DELEGATED DECISION TO DETERMINE PLANNING APPLICATIONS

Reference No:	2025/62/90809/E
Site Address:	Grange Nurseries, North View Road, East Bierley, BD4 6NS
Description:	Demolition of existing extensions and porch, erection of extensions and sun lounge to rear with associated works
Recommending Officer:	Nicole Helliwell

Officer Report

DETAIL
PROPOSED SITE PLAN WITH ENTRANCE
SLOPING DRIVE DOWN TO HARDSTANDING
AND PARKING BAYS WITH A CHARGING POINT

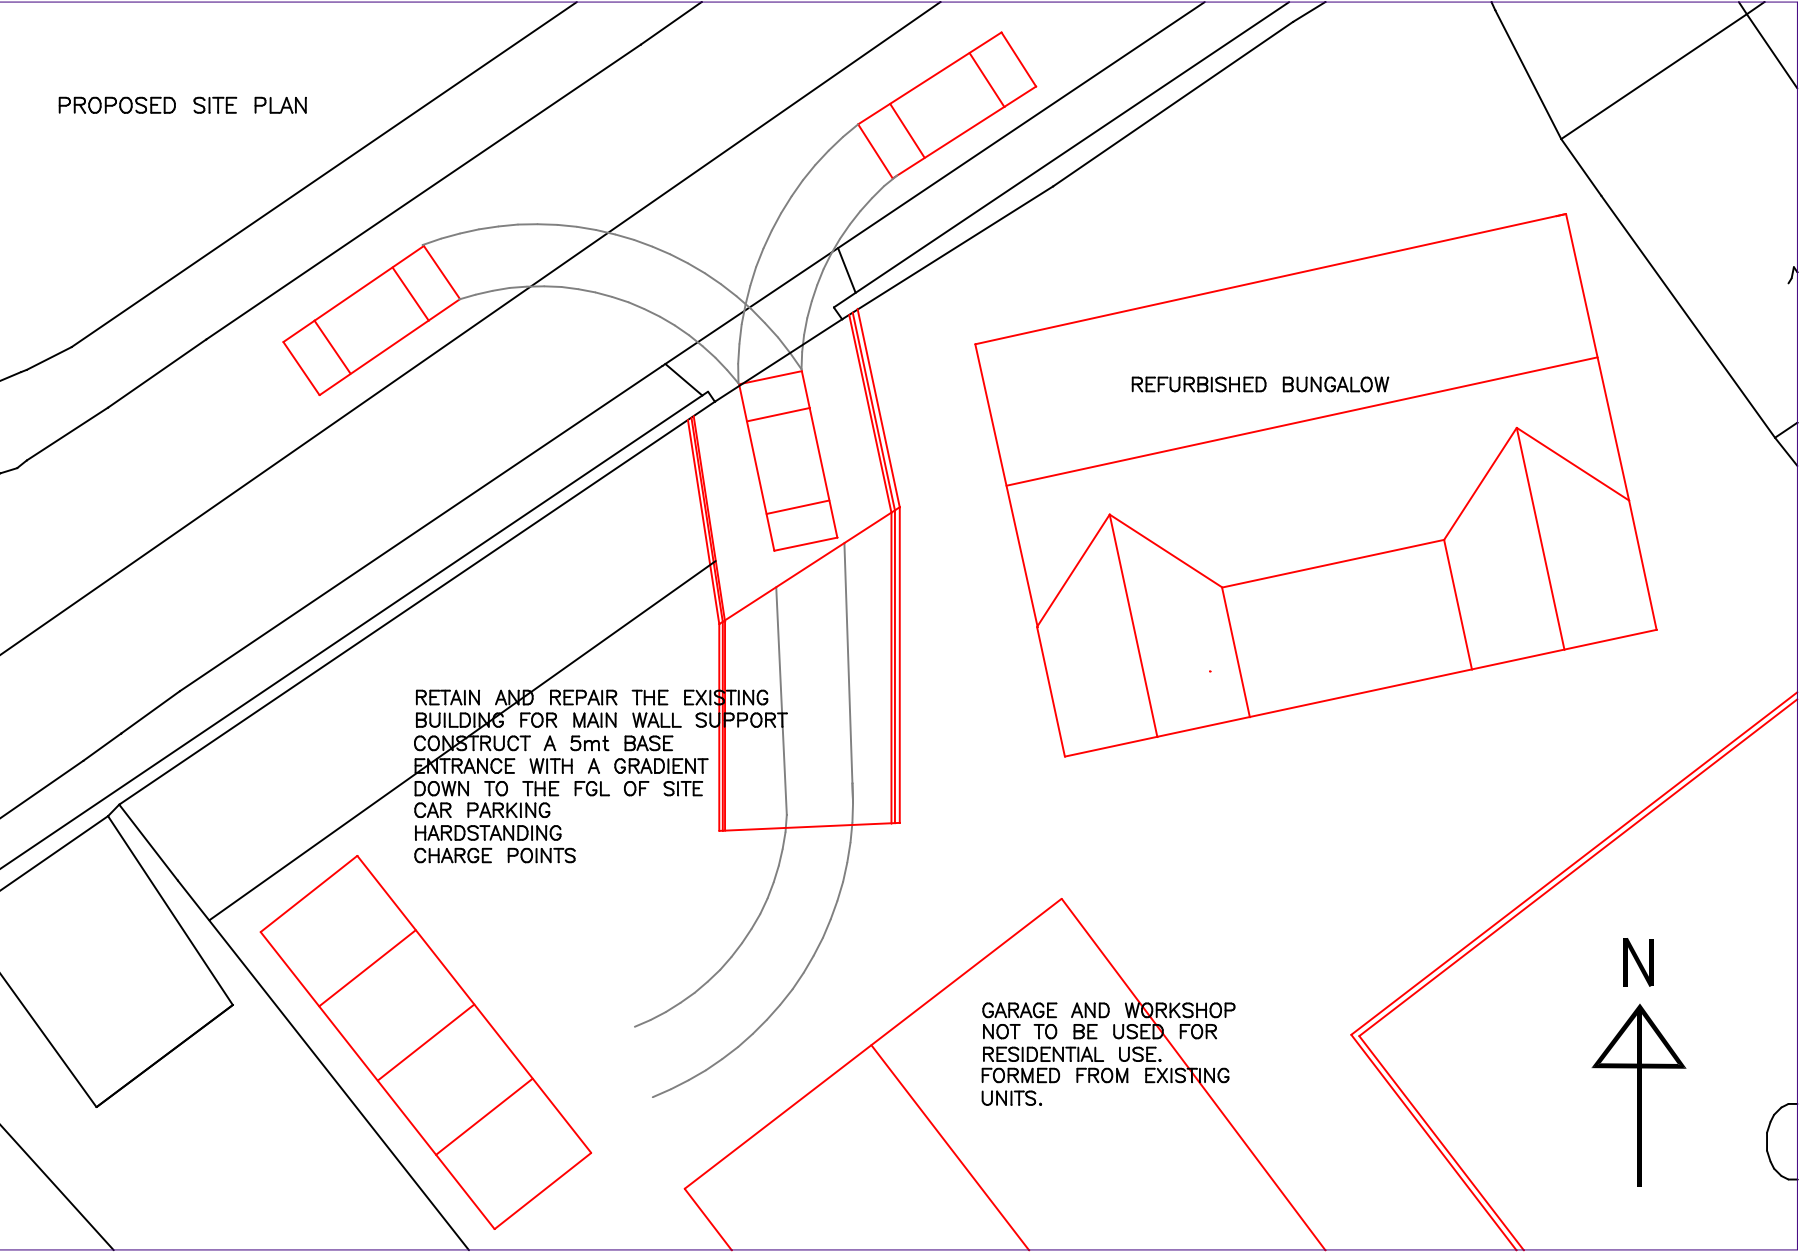
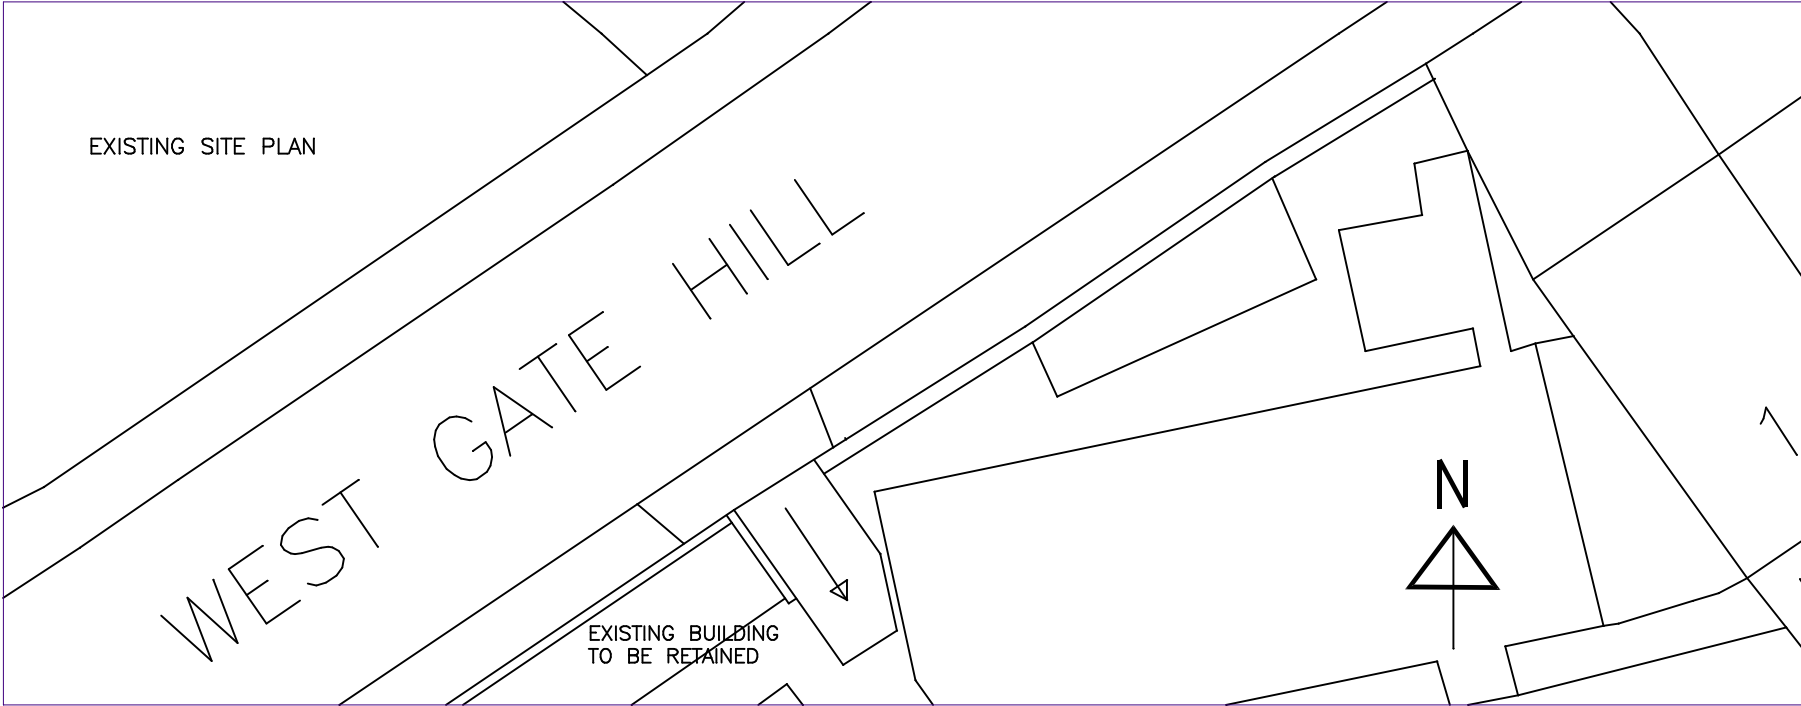
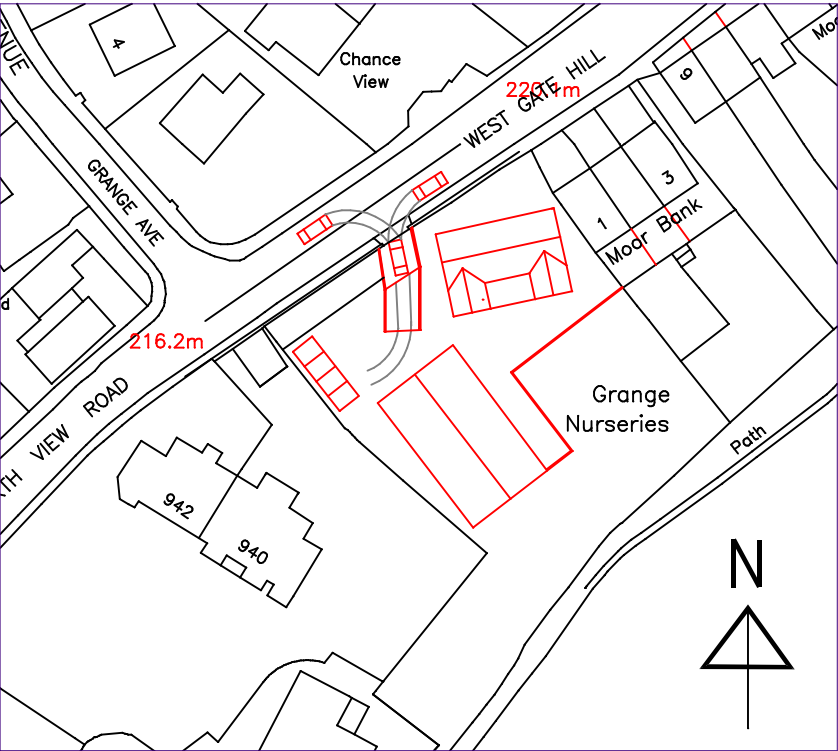
The width of the proposed access is shown as being approximately 4m wide which is acceptable. Any proposed gates should only open into the site and not obstruct the highway. The proposed access will need to be constructed under a section 184 agreement of the 1980 Highways Act (vehicle crossings over footways and verges). The applicant would be required to consult the Design Engineer (Kirklees Street Scene: 01484 221000) with regard to obtaining this permission and approval of the construction specification. Interference with the highway without such permission is an offence which could lead to prosecution.

Manual for Streets also states that for a 30mph speed limit sight lines of 2.4m x 43m should be achievable and demonstrated on a suitable plan. Any shortfall

of this requirements should be in accordance with 85%ile wet weather speed readings (if below 30 mph). A condition has been added requiring sightlines to be provided prior to development commencing on site. There is an existing bus stop and shelter on North View Road that may need relocating if it obstructs visibility.

The ramp into the lower internal area appears to be too steep and short to allow for vehicle access to the internal area. The ramp should ideally be at a gradient of no more than 1 in 10. As such, KC Highways have confirmed that details should be provided showing the levels and gradient of the ramp prior to commencement to ensure the new access and ramp does not compromise the stability of the adjacent retaining wall of the adopted highway.

5. No development shall take place until details of the siting, design, structural calculations and material to be used in the construction of retaining walls/structures near or abutting highway have been approved in writing by the Highways Structures team. Thereafter the development shall not be brought into use until the approved works have been constructed. The said works shall be maintained throughout the lifetime of the development.

6. Before development commences, sightlines of 2.4m x 43m along North View Road shall be shown on a plan and presented to the local planning authority for written approval. The development shall not be brought into use until the approved scheme has been implemented and thereafter retained throughout the lifetime of the development.
